**SSI 9775 – NOTICE OF EXHIBITION – NEW MAITLAND HOSPITAL (STAGE 2 – DETAILED DESIGN AND CONSTRUCTION), LOT: 7314 DP: 1162607, PART LOT: 401 DP: 755237, METFORD ROAD METFORD**

Roads and Maritime have reviewed the Transport Impact Assessment for Stage 2, by GTA consultants dated 17 May 2019, and the associated Sidra files, and make the following comments:

26/7/2018 - NEW ENGLAND HWY / CHISHOLM RD, GREENHILLS

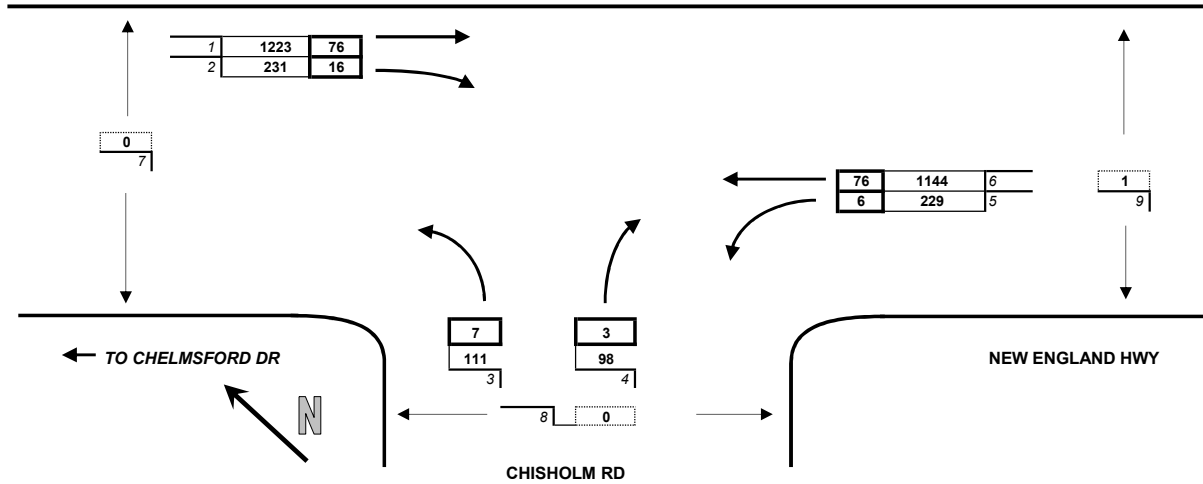
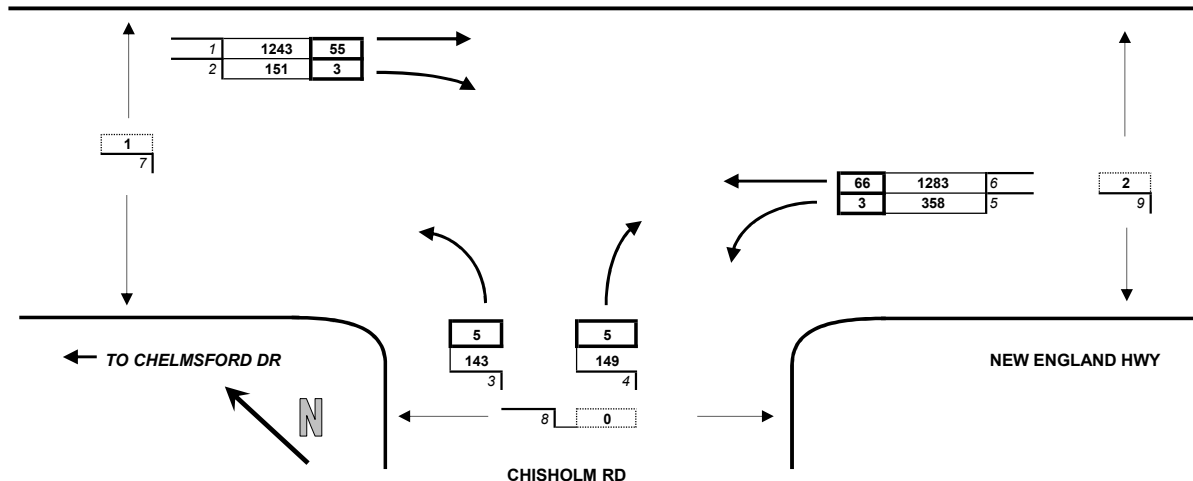
- Notes from 2032 PM peak:

The Degree Of Saturation (DOS) indicates that the nominated lanes are approaching saturation as a result of the development traffic.

- Queuing increases from 230m pre-development to 460m post-development. The DOS on the south-east NEH leg increases from 0.77 to above 0.93.
- The DOS on the right turn north-west NEH leg increases from 0.74 to above 0.92.

Roads and Maritime recommend that the above points be checked within the modelling to ensure its accuracy, with additional comments provided where required. Should you require further information please contact Marc Desmond on 0475 825 820 or by email at [development.hunter@rms.nsw.gov.au](mailto:development.hunter@rms.nsw.gov.au)
